PLANNING APPLICATION 2024/62/91316/E

OBJECTIONS AGAINST THE PROPOSALS

For the conversion of existing dwelling and outbuilding to create 6 apartments and erection of 17 dwellings

Location: CLOUGH HOUSE, 236 LEEDS RD, BIRSTALL, BATLEY WF17 0HW

1 PROPOSED SITE LAYOUT  
1 : 500

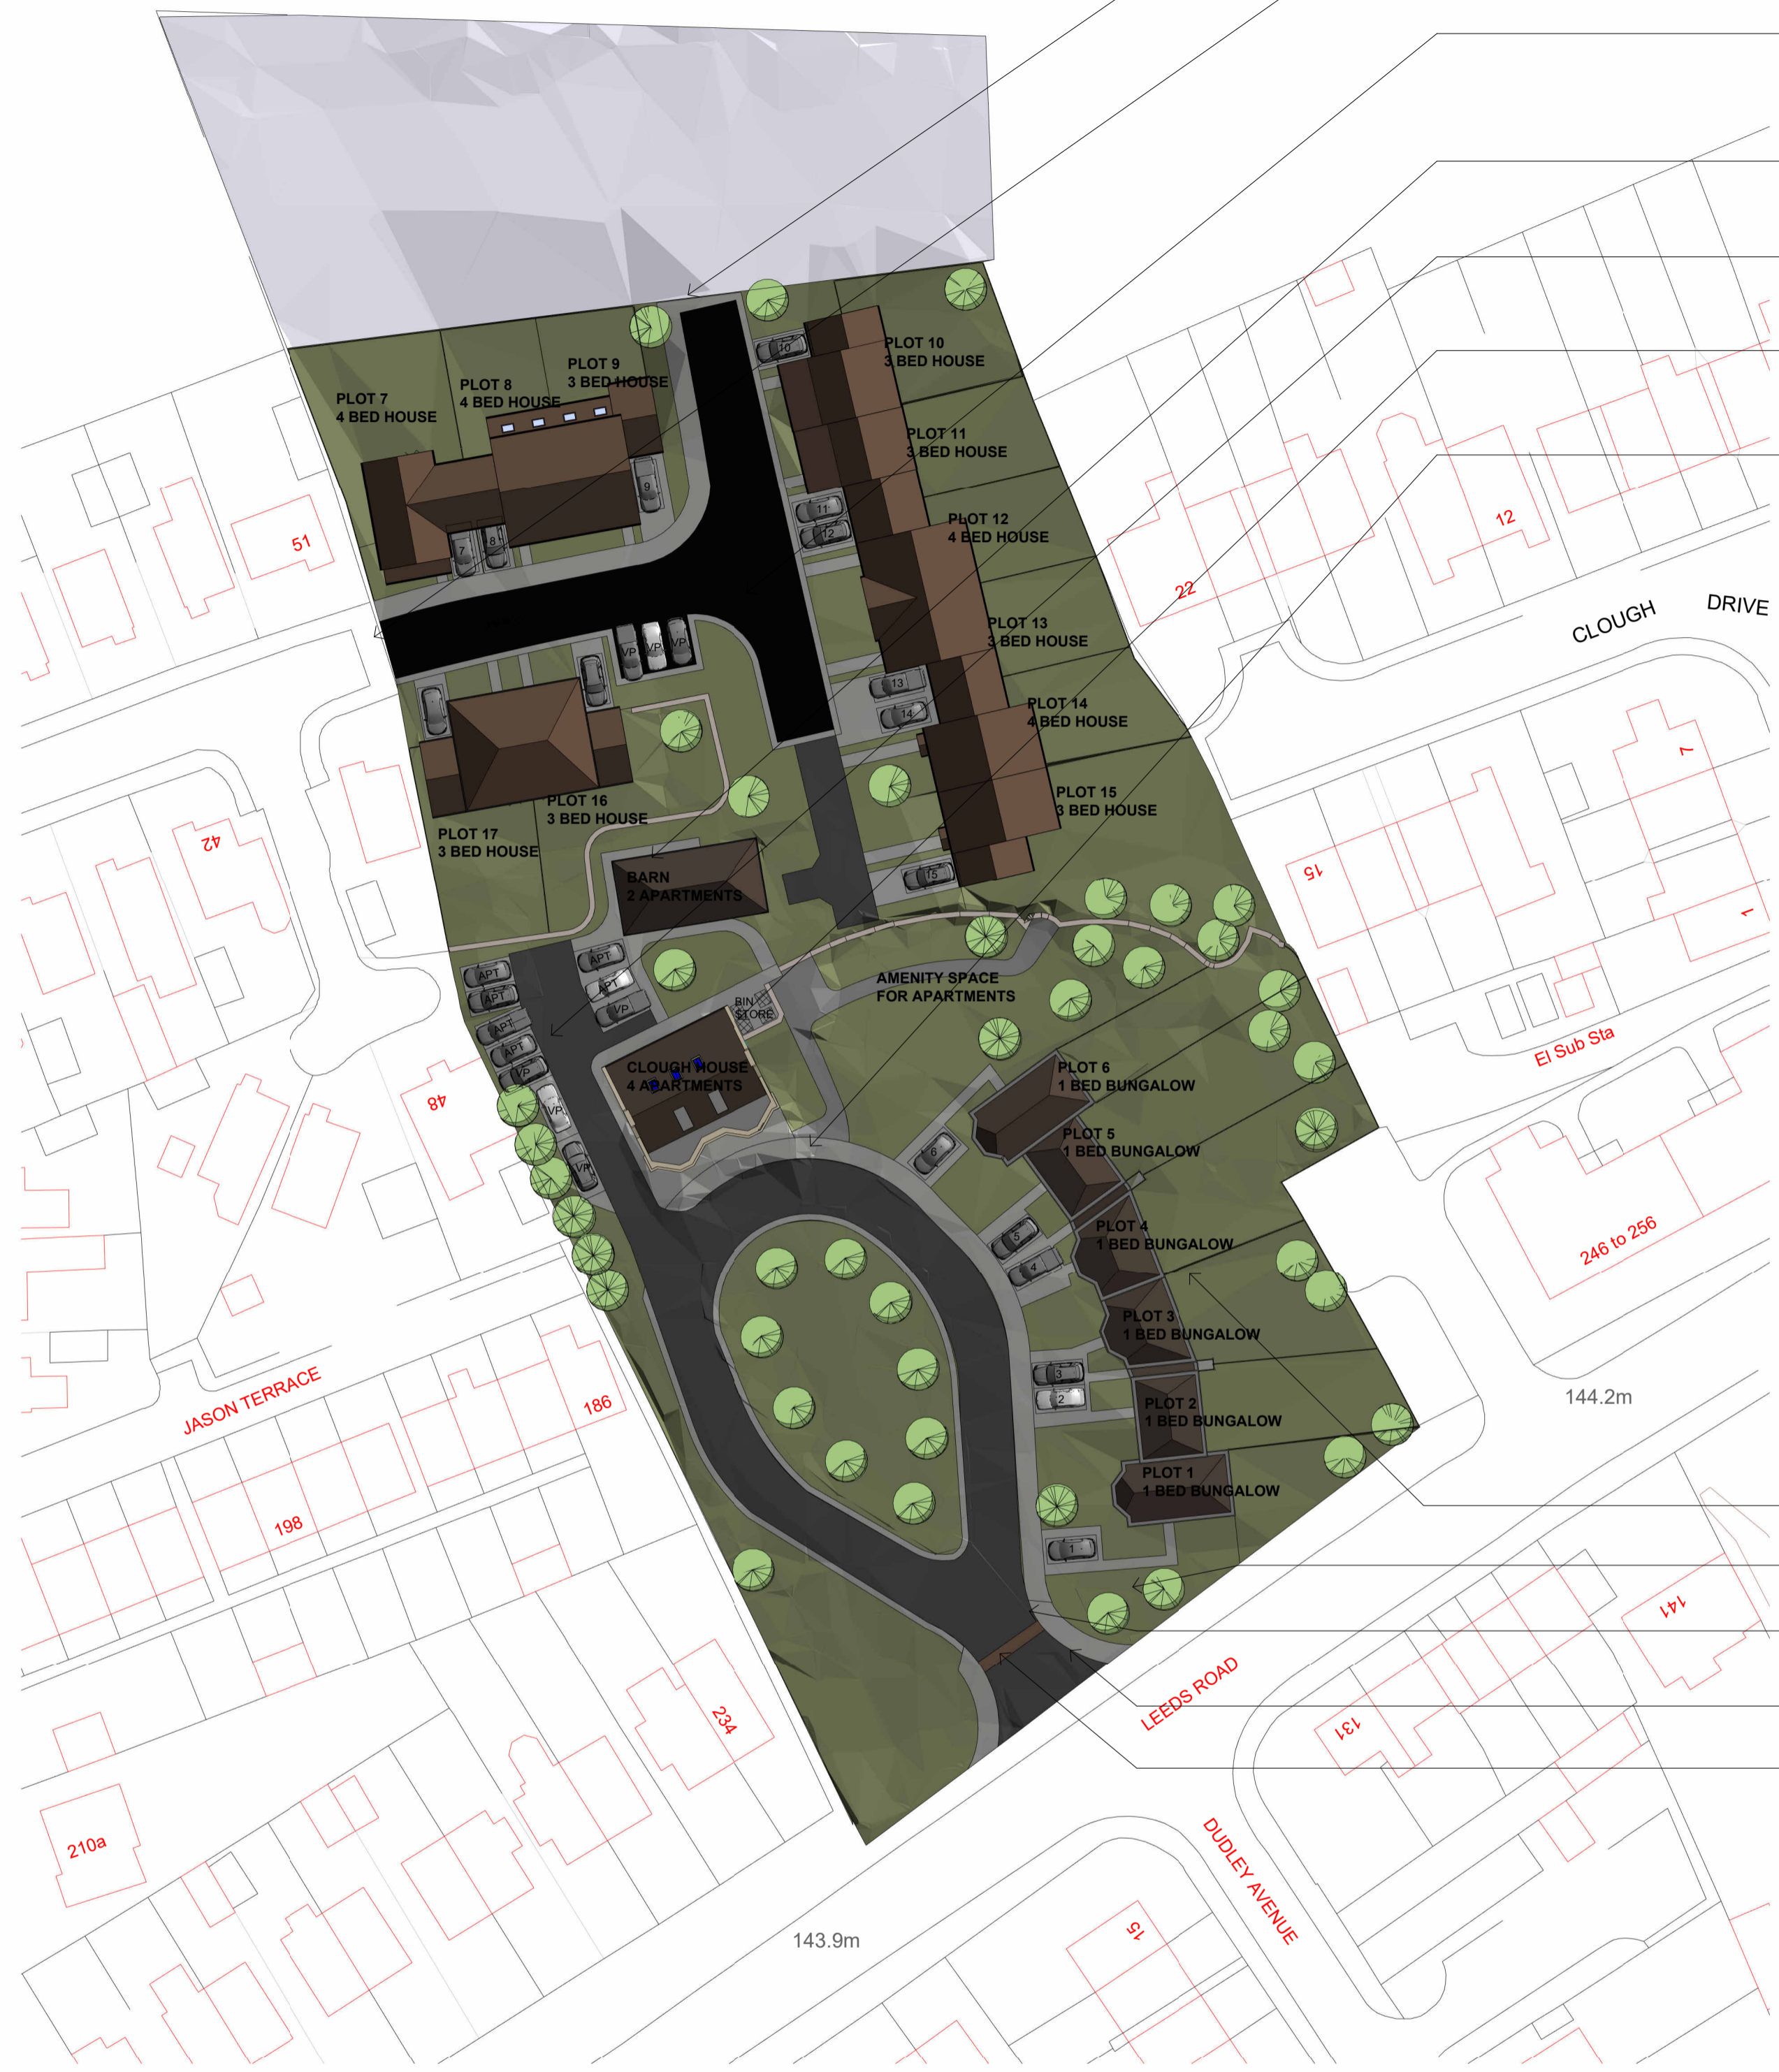
- The plans propose 11 dwellings at the north section of the site to be accessed via Moat Hill Farm Drive but there are inconsistencies between the planning application, the transport assessment and the floor plans for plots 7 – 17 as follows.
 - Application form: 6 x 4-bedroom and 5 x 3-bedroom properties
 - Transport Assessment: 4 x 4-bedroom and 7 x 3-bedroom properties
 - Floor Plans for plots 7 – 17: shows 7 x 4-bedroom and 4 x 3-bedroom properties

Assuming the plans preside over the other documents for the proposals being submitted to the Planning Office for approval, then the intentions would be seeking approval for 7 x 4-bedroom and 4 x 3-bedroom properties. Consequently, the transport assessment has inadequately under-estimated the traffic impact for the development on Moat Hill Farm Drive due to inaccurate data being used in the assessment. I would estimate conservatively that at least 30 additional cars would be requiring access to Moat Hill Farm Drive as a consequence of these plans and I believe that there is insufficient parking provision being provided and would necessitate on-road parking. Given that the proposal only includes 0.5 metre pavements on one side, this is likely to be detrimental to all users of the proposed adopted road and is not inclusive for the community residents.

I note also that the north section “turning point” is positioned to facilitate further potential residential development to the north of the development site which is not yet included within this planning application. I am deeply concerned of the impact on the safety of vehicle, pedestrian and service access for the existing Moat Hill Farm Drive residents in addition to the new residents.

- I note that the provision of these plots comes at the expense of pavement widths at either side of the access road leading from Moat Hill Farm Drive and hence compromises community safety. As the house types are 3 bedroomed, I assume that the target and potential market will be towards families and therefore it is essential that the pavements continue from Moat Hill Farm Drive at the same width as the existing road and pavements.

Description
PROPOSED HOUSE ELEVATIONS & 3D VIEWS

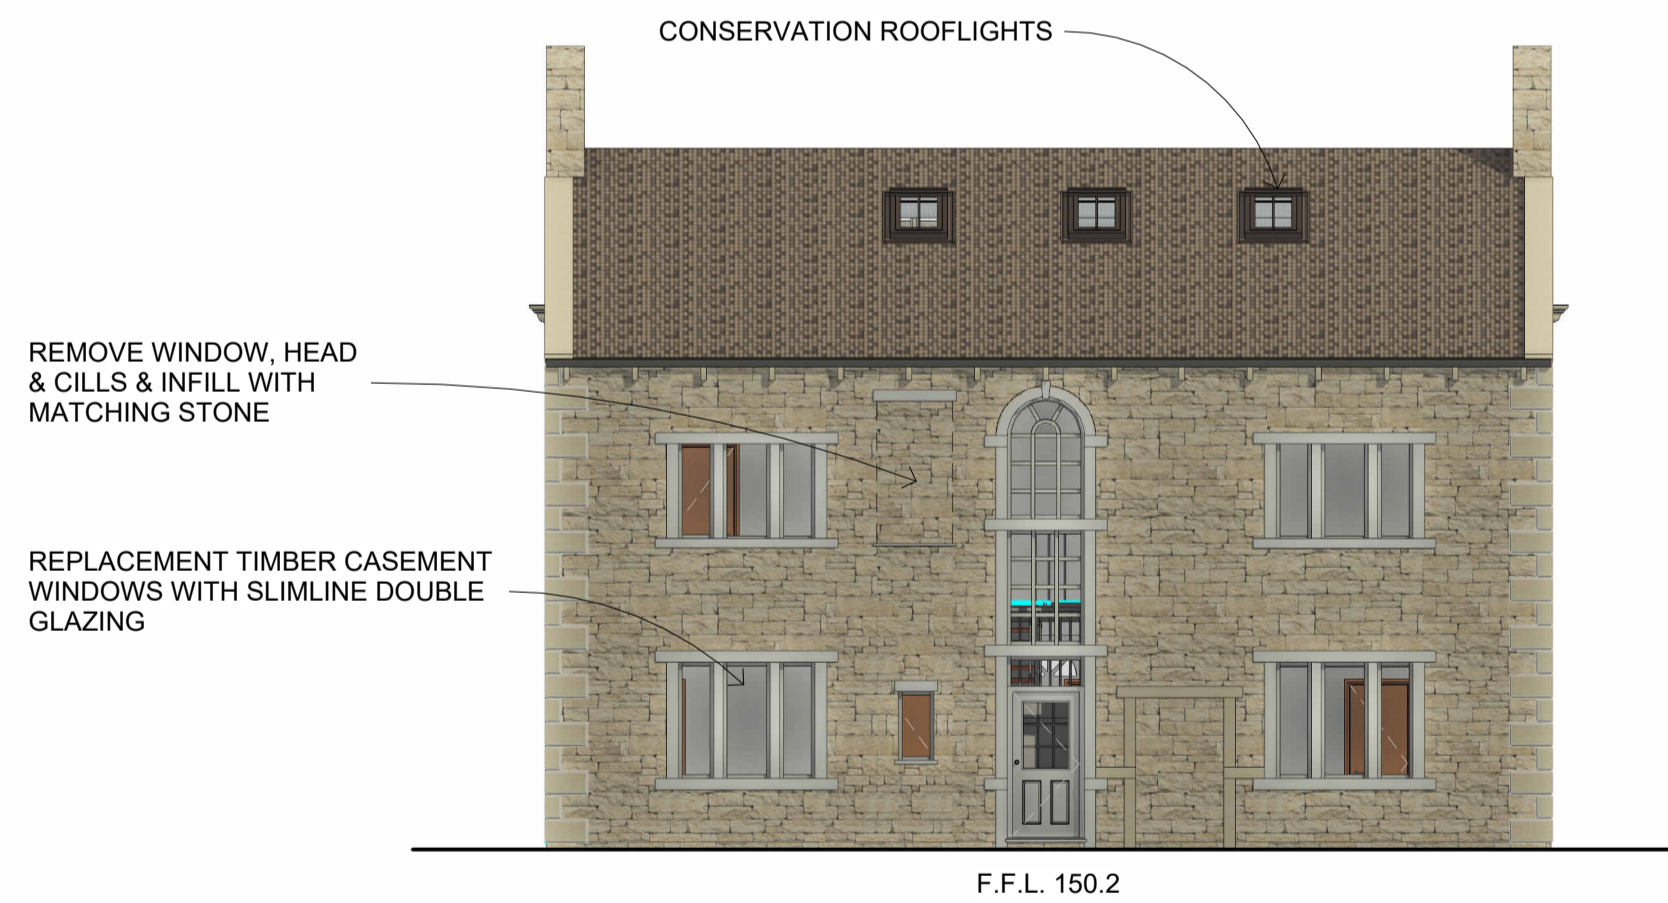
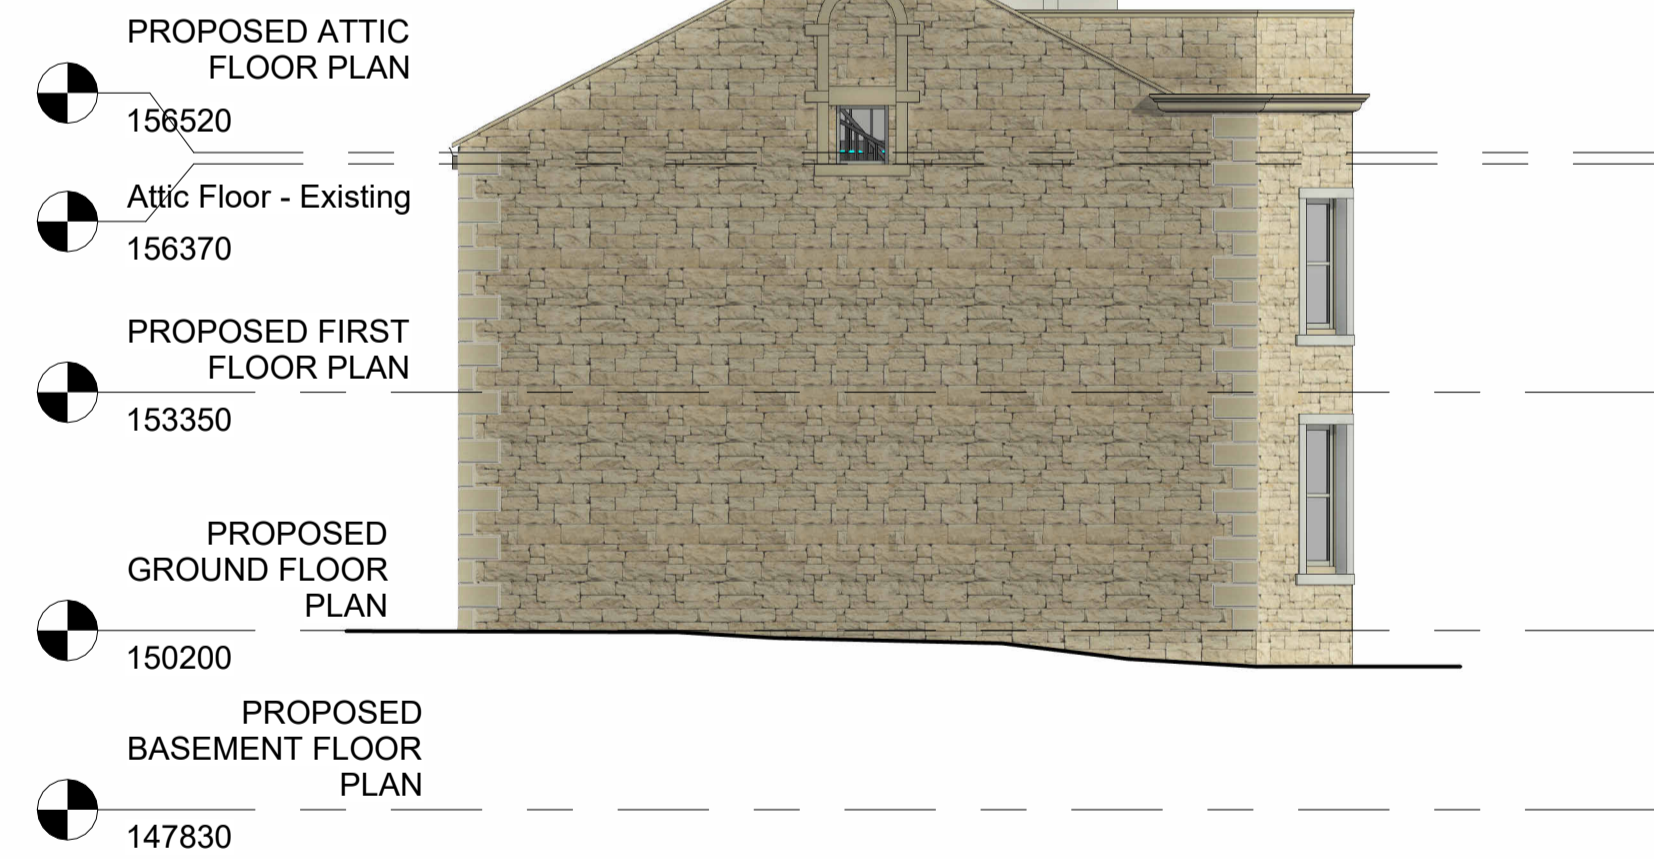
2. Detrimental impact upon residential amenities: Plot 16 and 17 New pair of 2 storey semi-detached dwellings and building line out of step with existing adjacent buildings on Moat Hill Farm Drive.

- The proposed location of plots 16 and 17 is directly behind the existing barn and Clough House which is a significant departure from the previous proposals on planning application 2022/62/92356E which had proposed to landscape this area, together with the provision of car parking spaces, rather than the creation of any new dwellings. I feel that this aspect of the proposals is a detriment for the following reasons:

- The context and setting of Clough House and the barn will be dominated by Plots 16 and 17 which will detract from the existing and historical prominence and setting of the existing buildings to the community.

- The building line is not being maintained from the existing dwellings on Moat Hill Farm Drive which would be a detriment to the overall line of sight, visibility and general character of the community.

- Given that the proposed dwellings will be targeted to the family market, there is insufficient garden space to these large 4-bedroomed homes for the children to play. If the proposals were amended for plots 16 and 17 to be landscaped, this would help to address the loss of open spaces.
